re: Geotechnical Review – Grading Plan
Proposed commercial Development
30 Frank Nighbor Place - Kanata, ontario

date: September 9, 2022

file: PG6153-MEMO.01

**LOCATION**  
CITY OF OTTAWA  
30 FRANK NIGHBOR PLACE: U-HAUL SITE

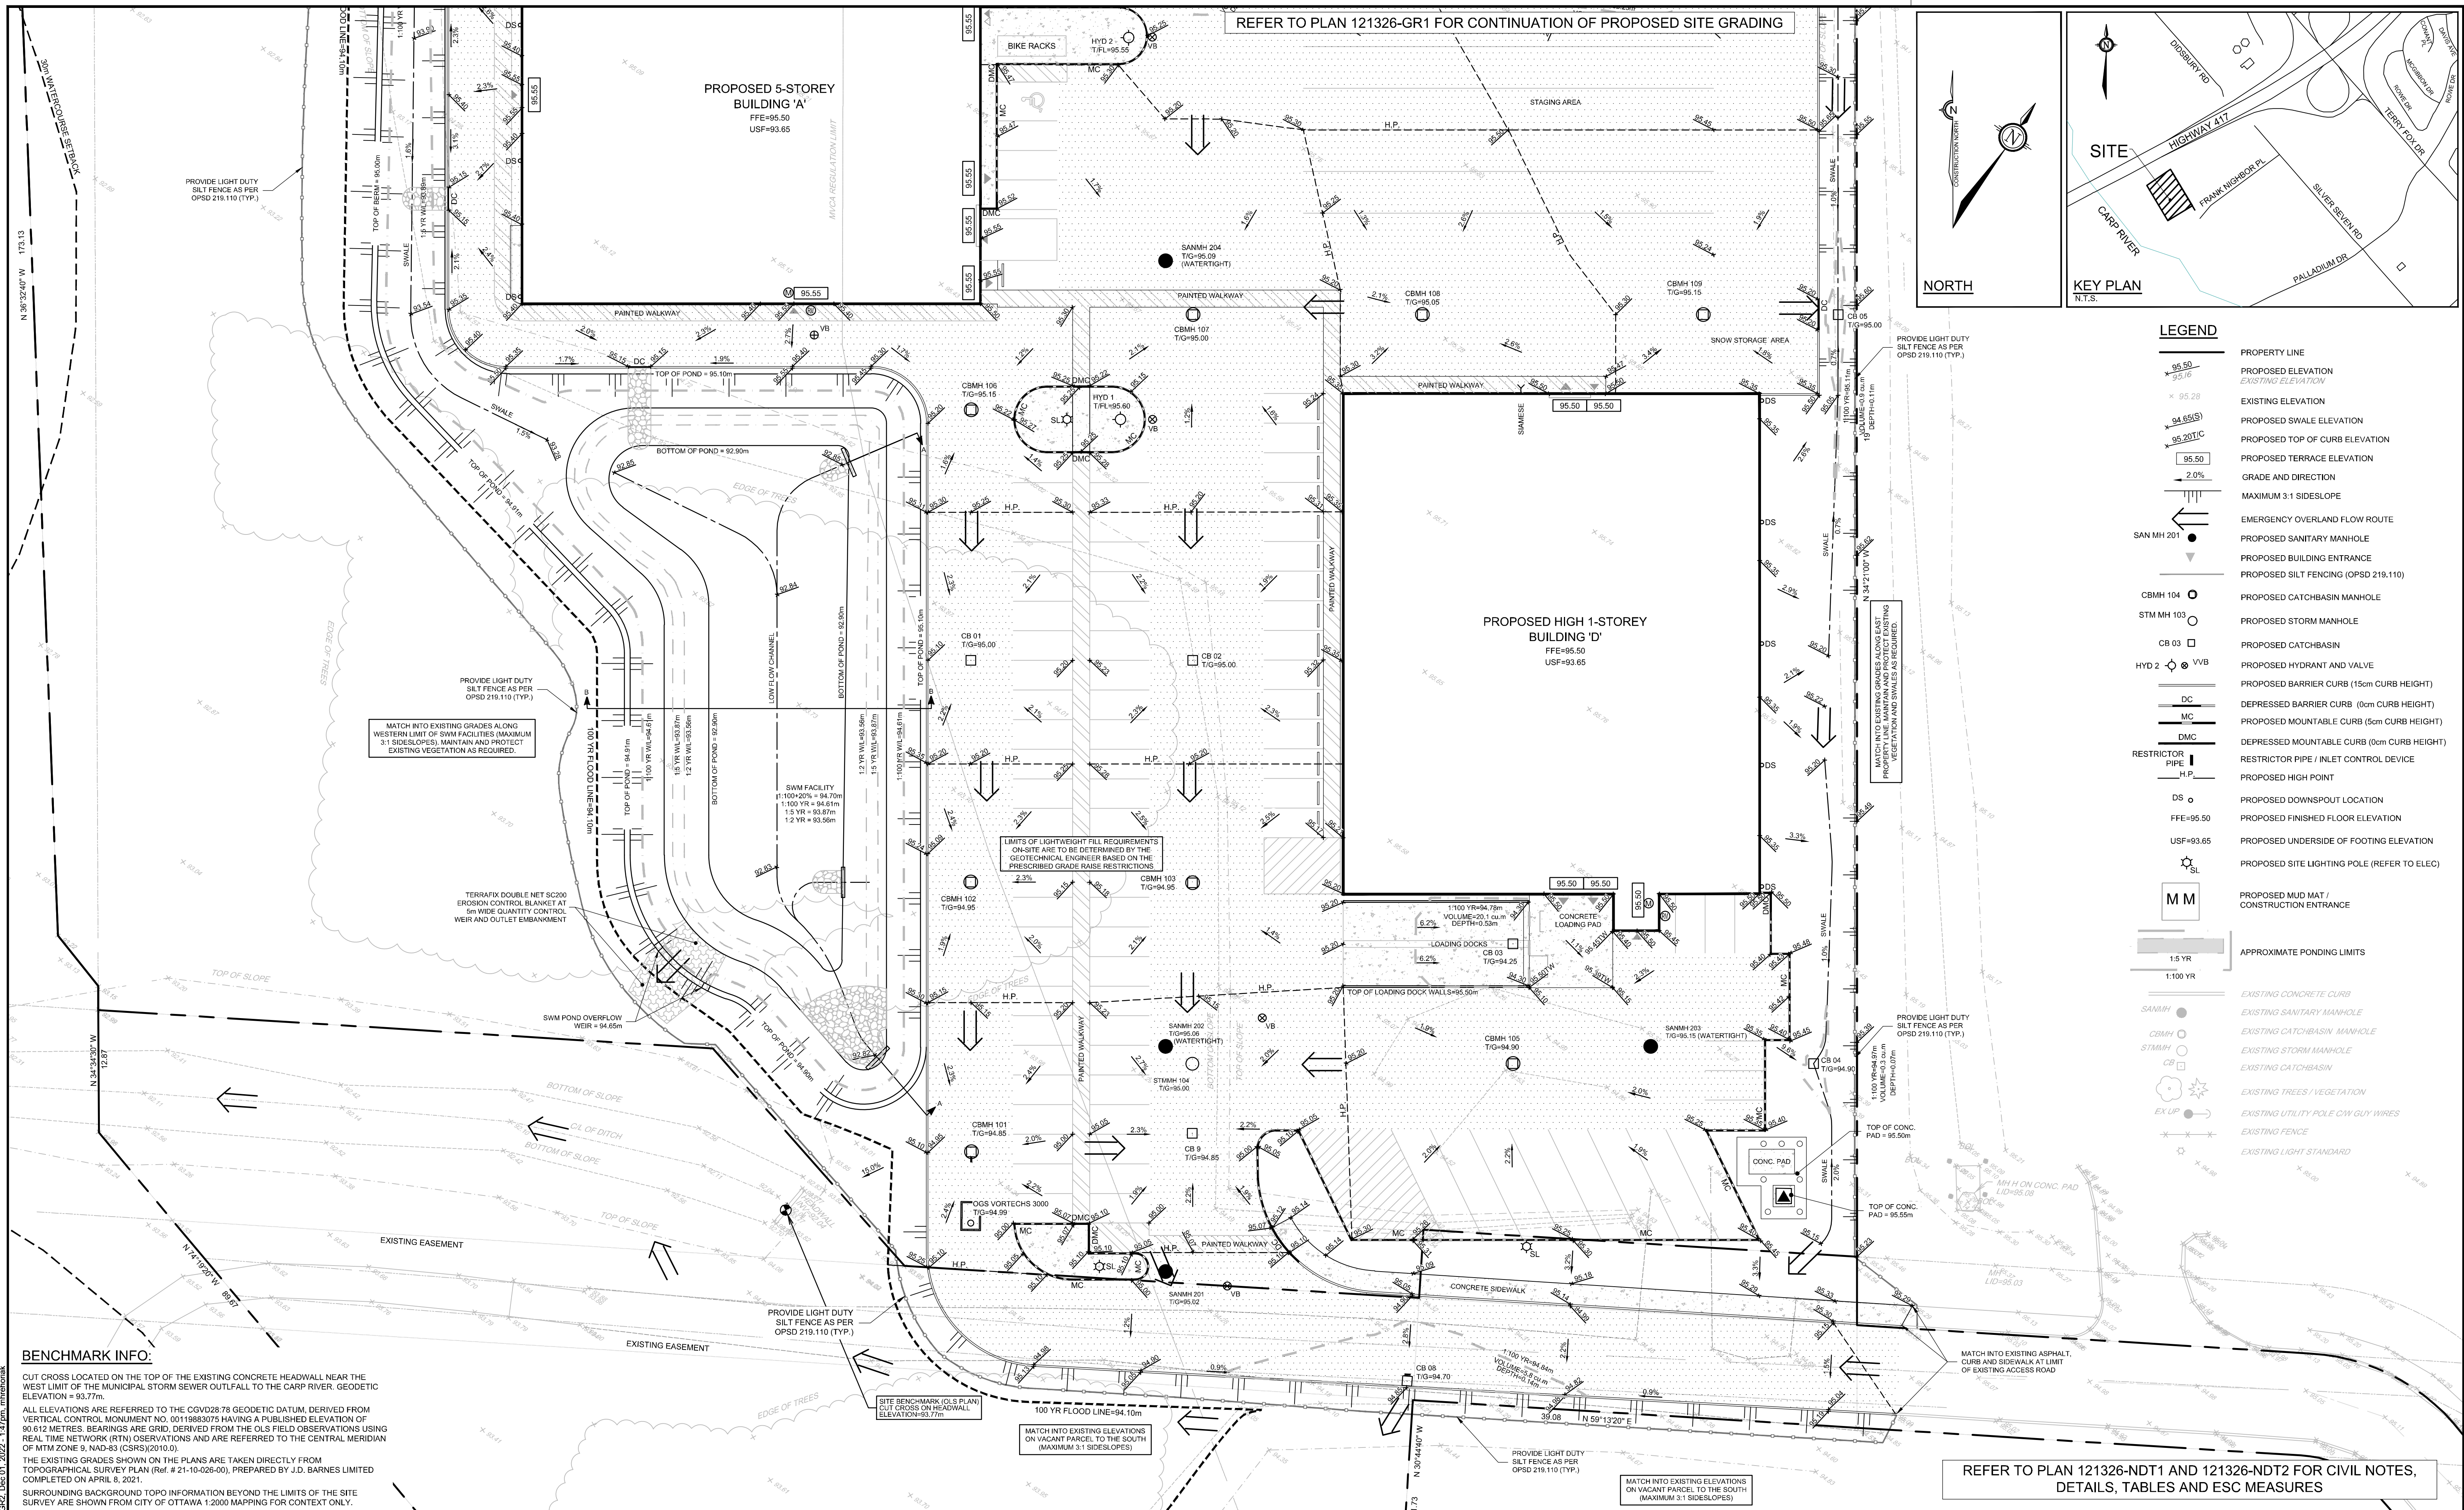
- Project No. 121326 - Drawings No. 121326-GR1 Revision 2 – Grading and Erosion & Sediment Control Plan dated August 30, 2022.
- Project No. 121326 - Drawings No. 121326-GR2 Revision 2 – Grading and Erosion & Sediment Control Plan dated August 30, 2022.

Based on our review of the above noted drawing, the proposed grading for the portable buildings B, C and D meets our recommended permissible grade raise recommendations provided in the geotechnical report. Therefore, no lightweight fill is required for the buildings B, C and D. However, Building A exceeds the permissible grade raise recommendations. Our grading summary and lightweight fill recommendations are presented in Table 1 – Soil Matrix Summary attached

The LWF material should consists of EPS 19 under the slab on grade, EPS 12 around the reminder of foundation under landscaped area and EPS 15 should be used below paved areas. The LWF should be placed against the foundation wall, above the footing and a minimum of 300 mm below the finish surface. The LWF EPS blocks should extend a minimum of 2.4 m outside the foundation wall with the thicknesses recommended in the attached Table 1.
